**Addendum No. 1**

RE: Contract ID: C201868

**Buncombe County (B-4037)**

Bridge Over South Hominy Creek and Approaches

MSE WALL #1 ENVELOPE

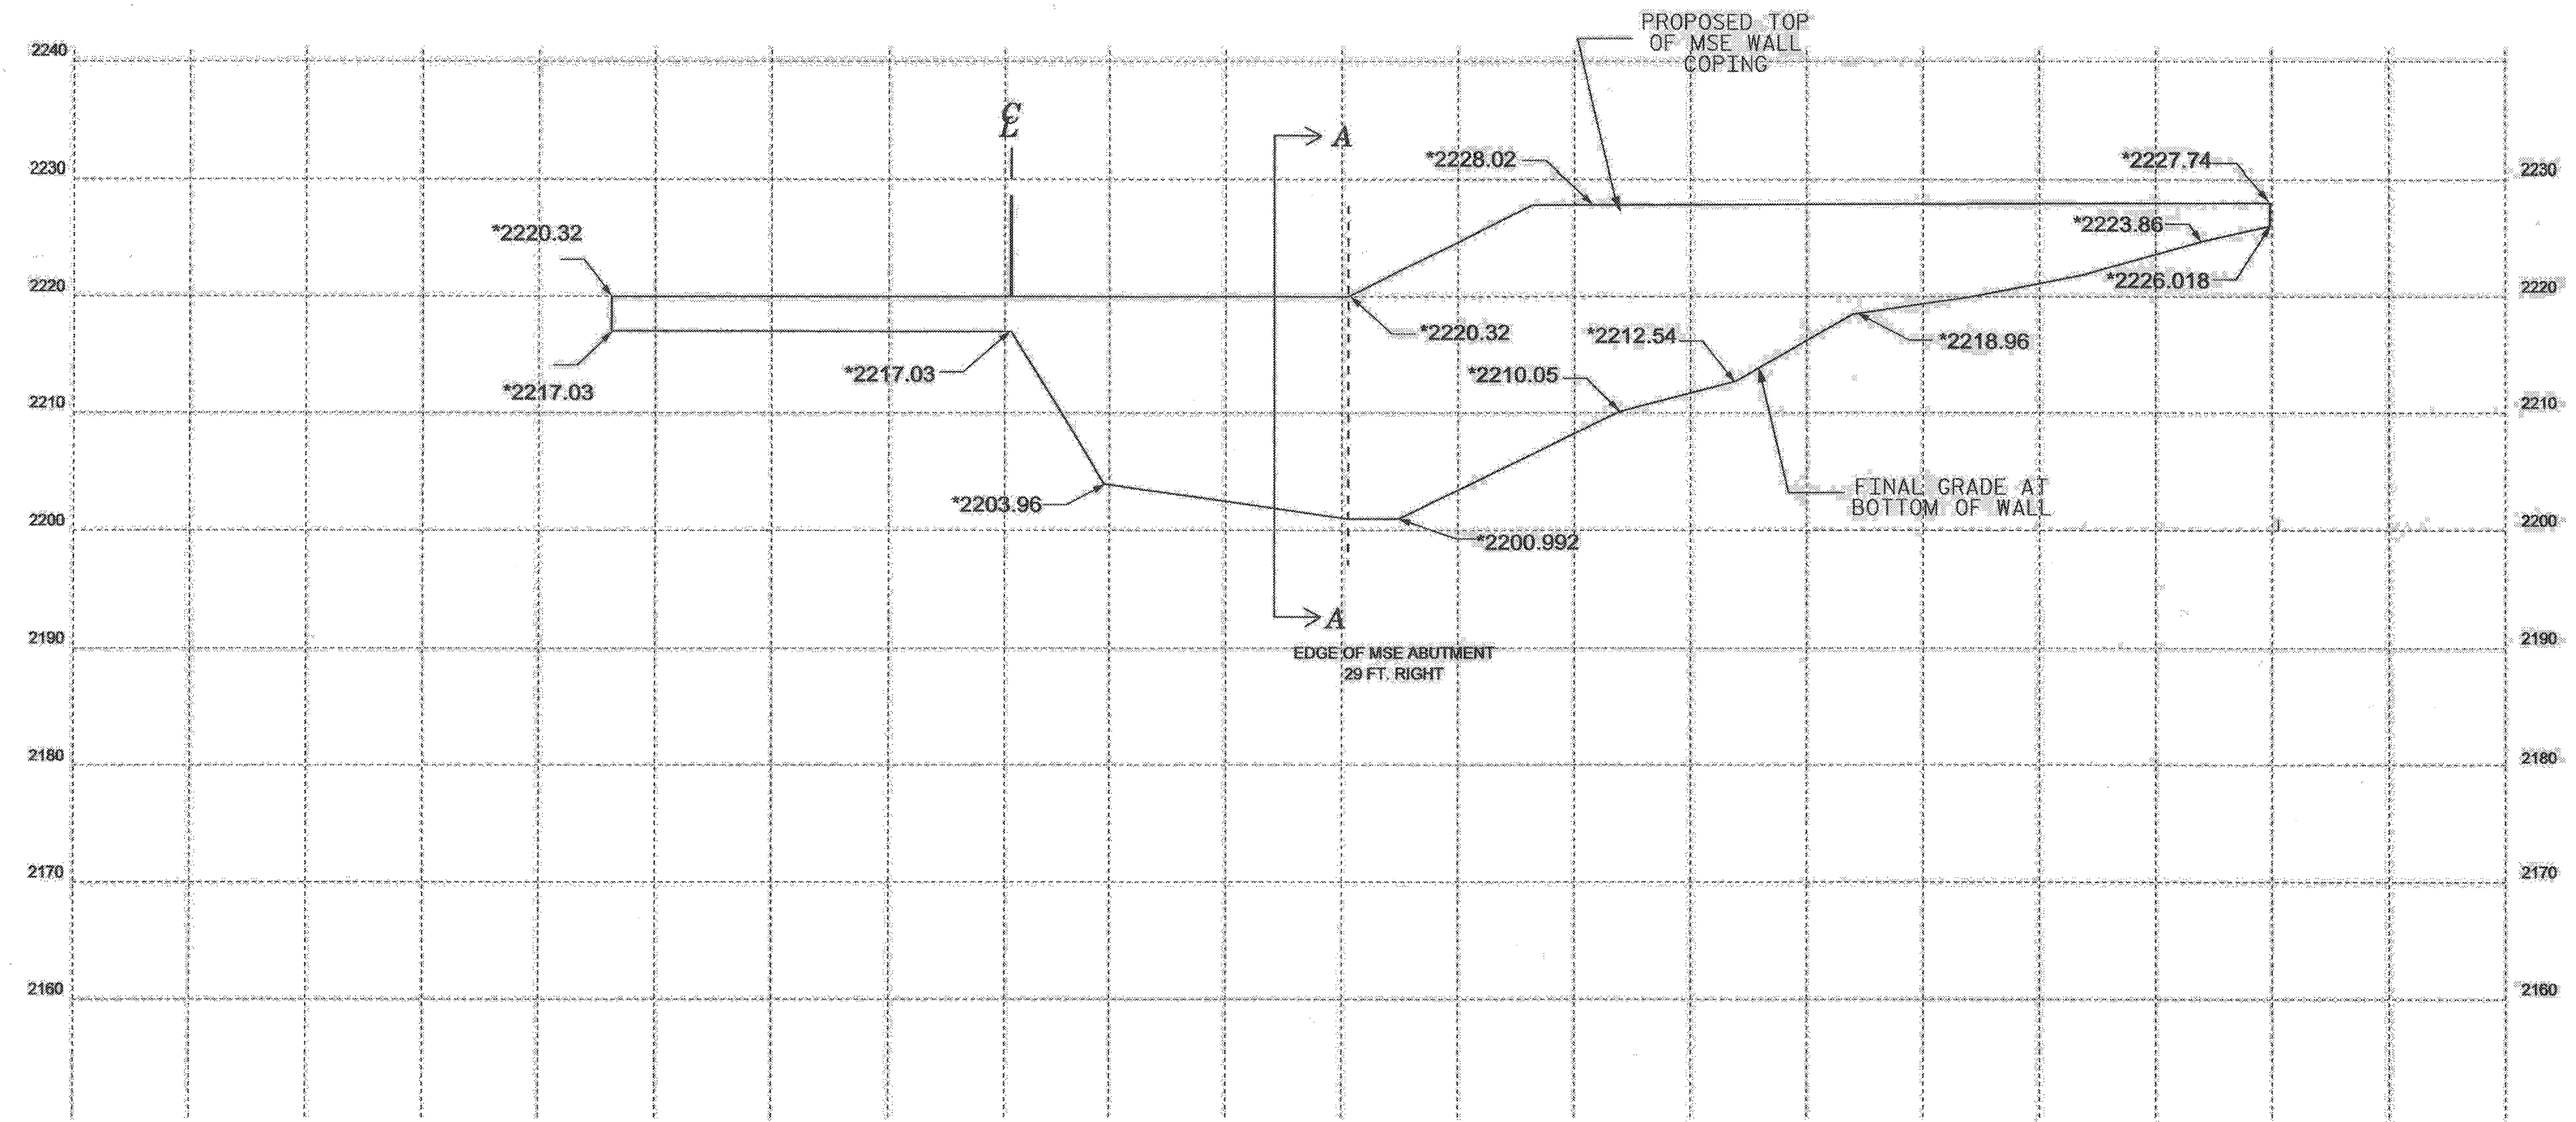
Sheet 2 of 4 of the Wall plans labeled "End Bent #1 MSE Wall" has been revised to correct some elevations. Please void Sheet 2 of 4 in your plans and staple the revised Sheet 2 of 4 thereto.
